Subject: Arrow
Page Label: [3] 3 20988 EG-GESC-INT - PG-INT
Page Index: 3
Lock: Unlocked
Checkmark: Unchecked
Author: dsdrice
Date: 7/20/2018 2:25:22 PM
Creation Date: 7/20/2018 2:24:42 PM
Color: ■
X:
Y:
Document Width:
Document Height:
Unit: Count
Measurement: 1 Count
Capture: No
File Name: ENG-SP17001-CD-Redlines-R4.pdf

C7.1

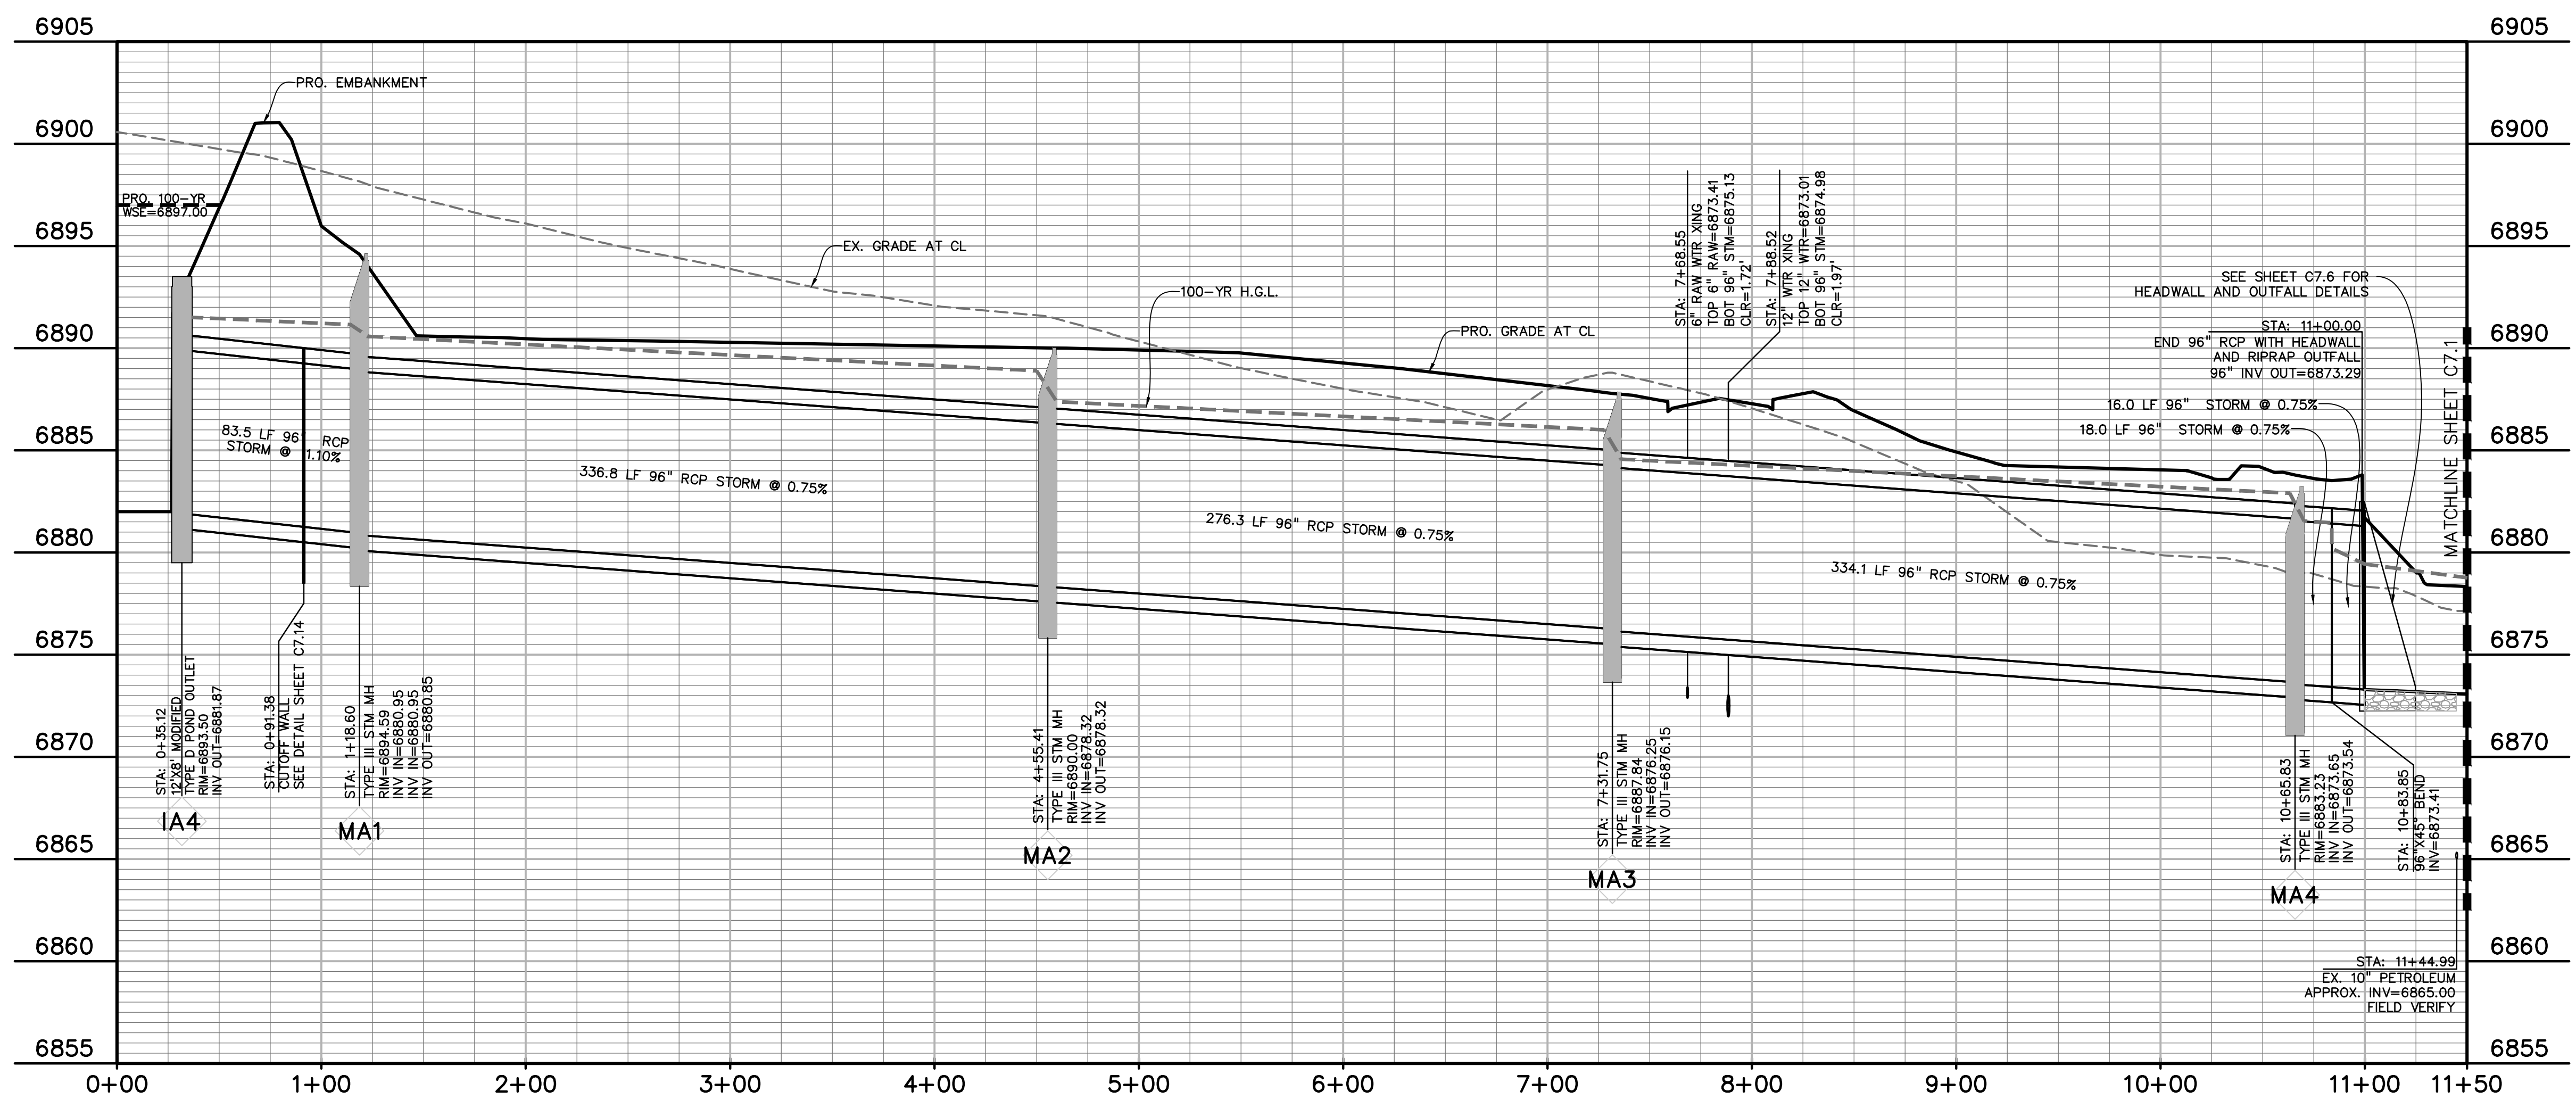
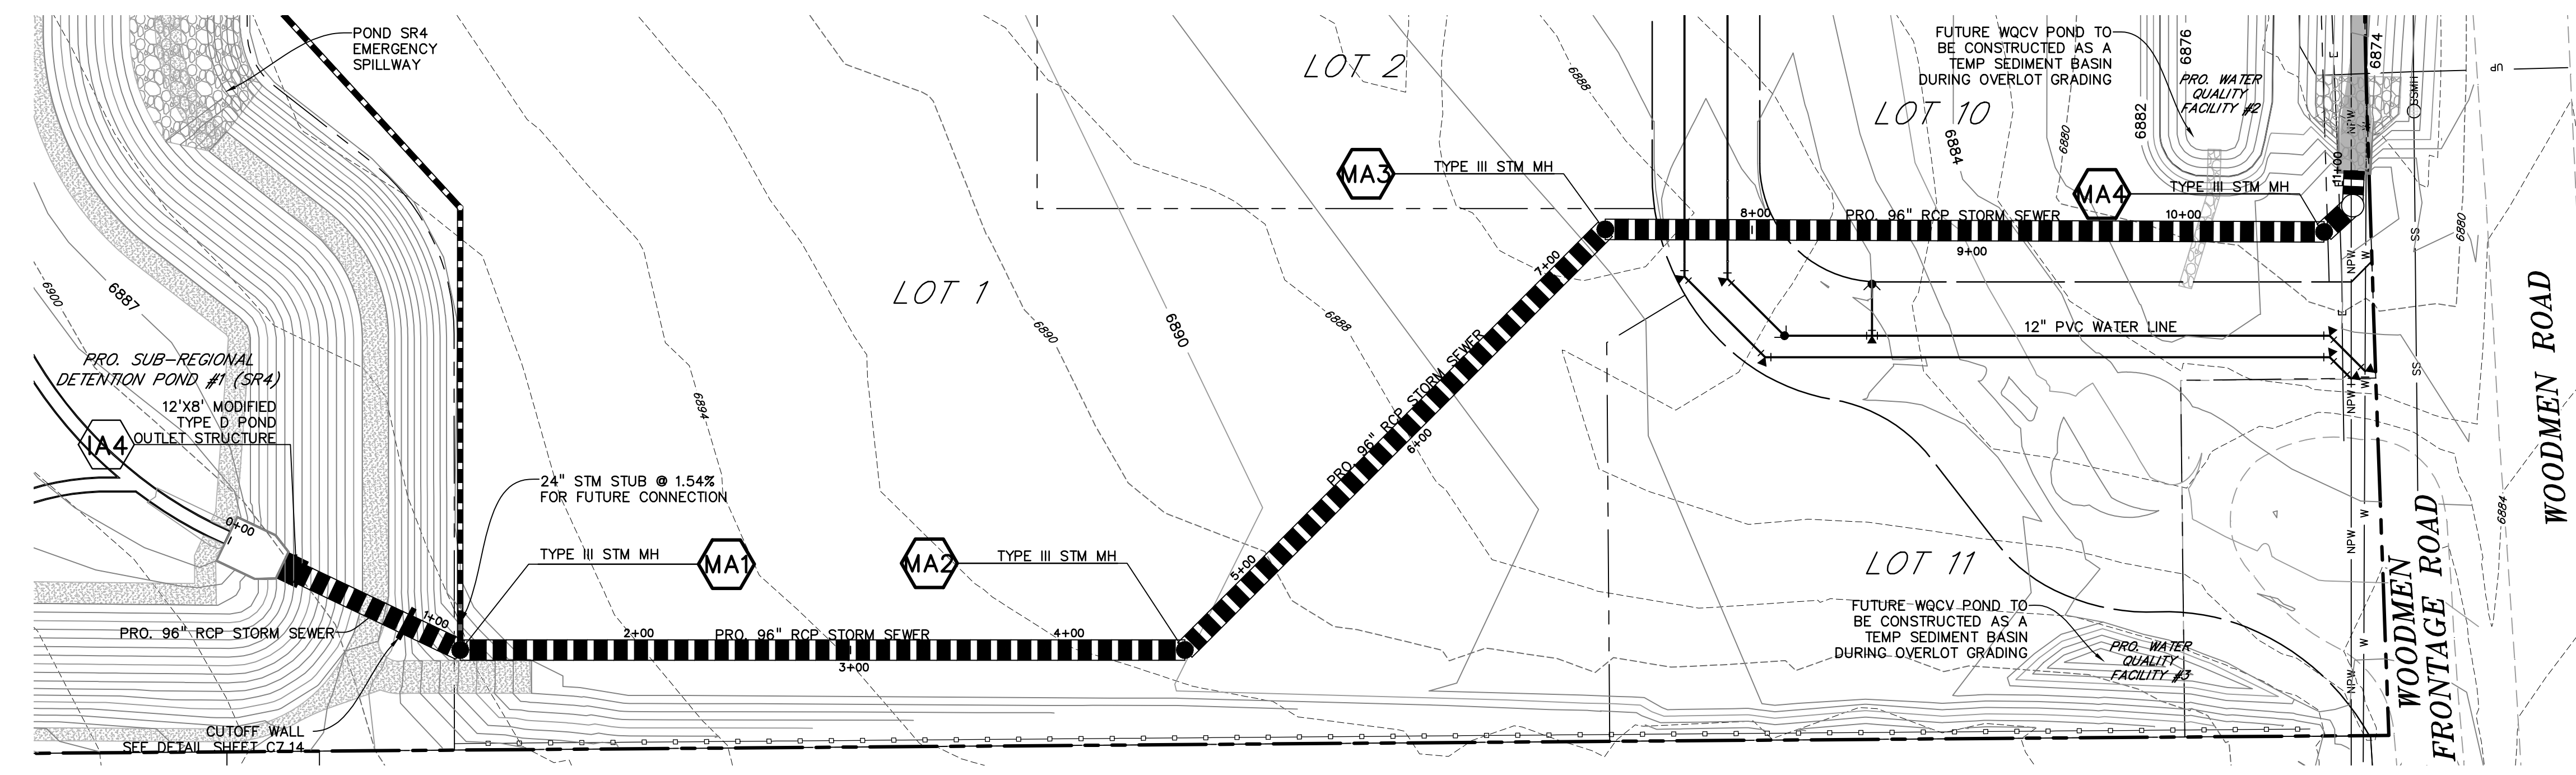
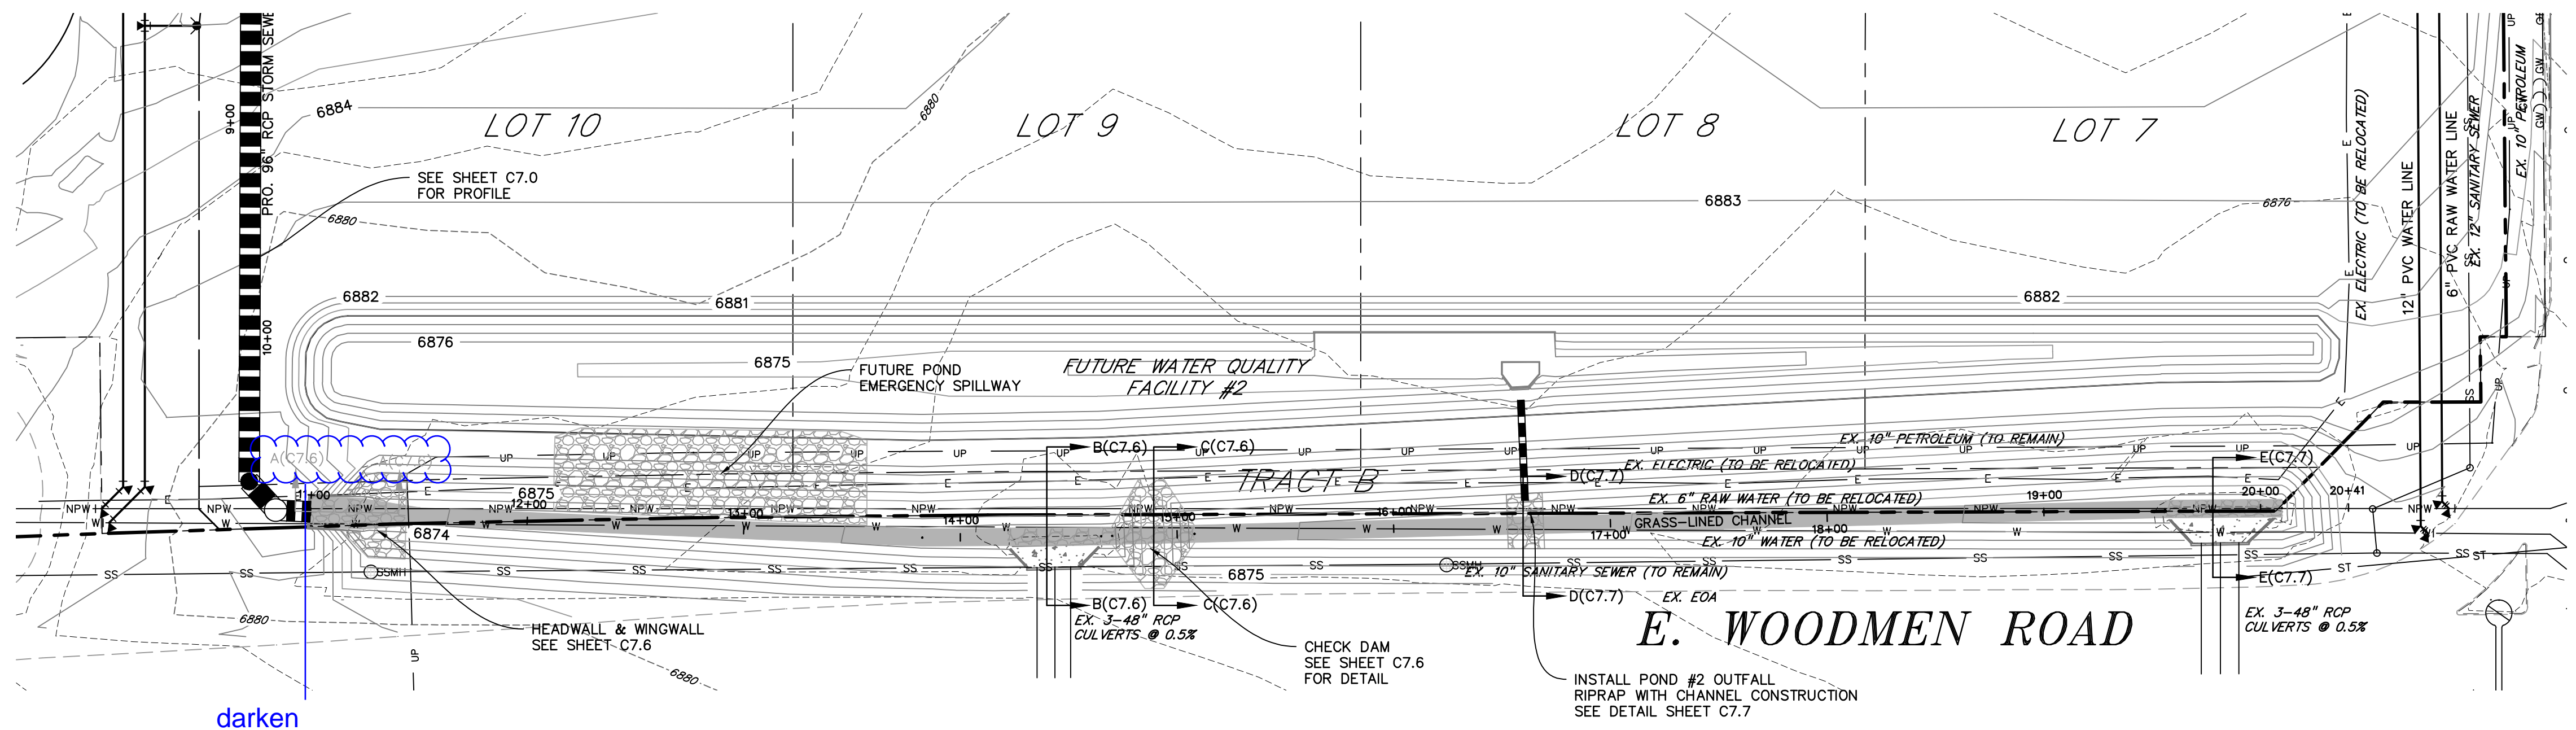
darken cross-section label

Extent of riprap for Q100 needs to be addressed.

Complete HGL

Provide Q100
Provide depth/Q100 elev.
Provide freeboard

OVERLOT GRADING, POND SR4 & UTILITY CONSTRUCTION DRAWINGS FOR
FALCON MARKETPLACE
 FALCON, COLORADO

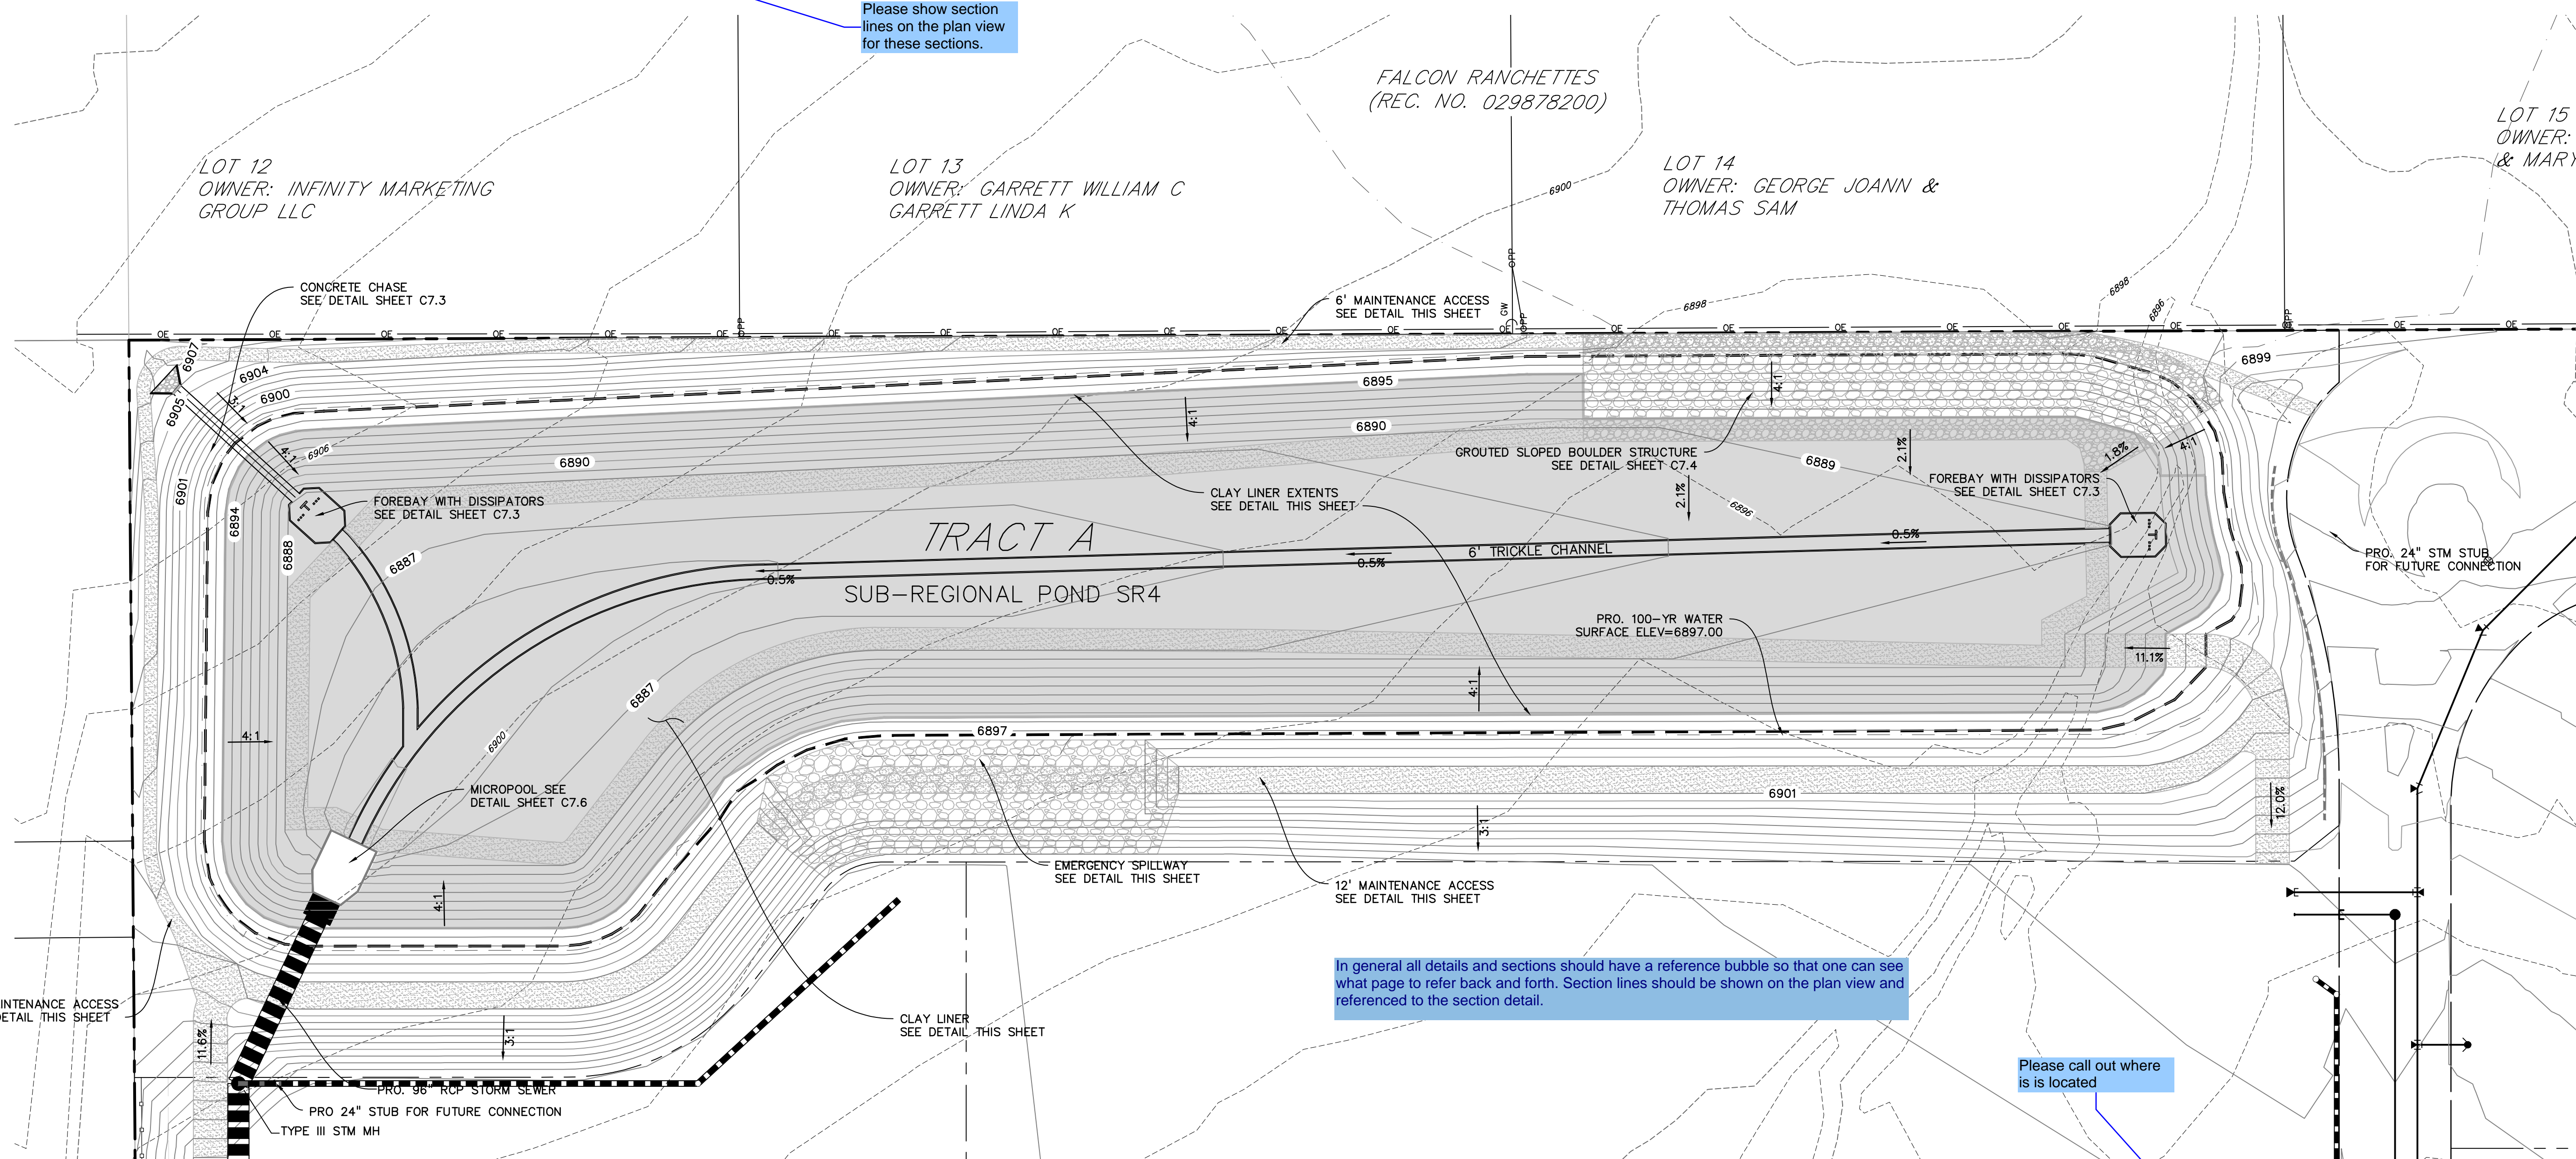
Verify with liner specs.

Provide specific details.

Please show section lines on the plan view for these sections.
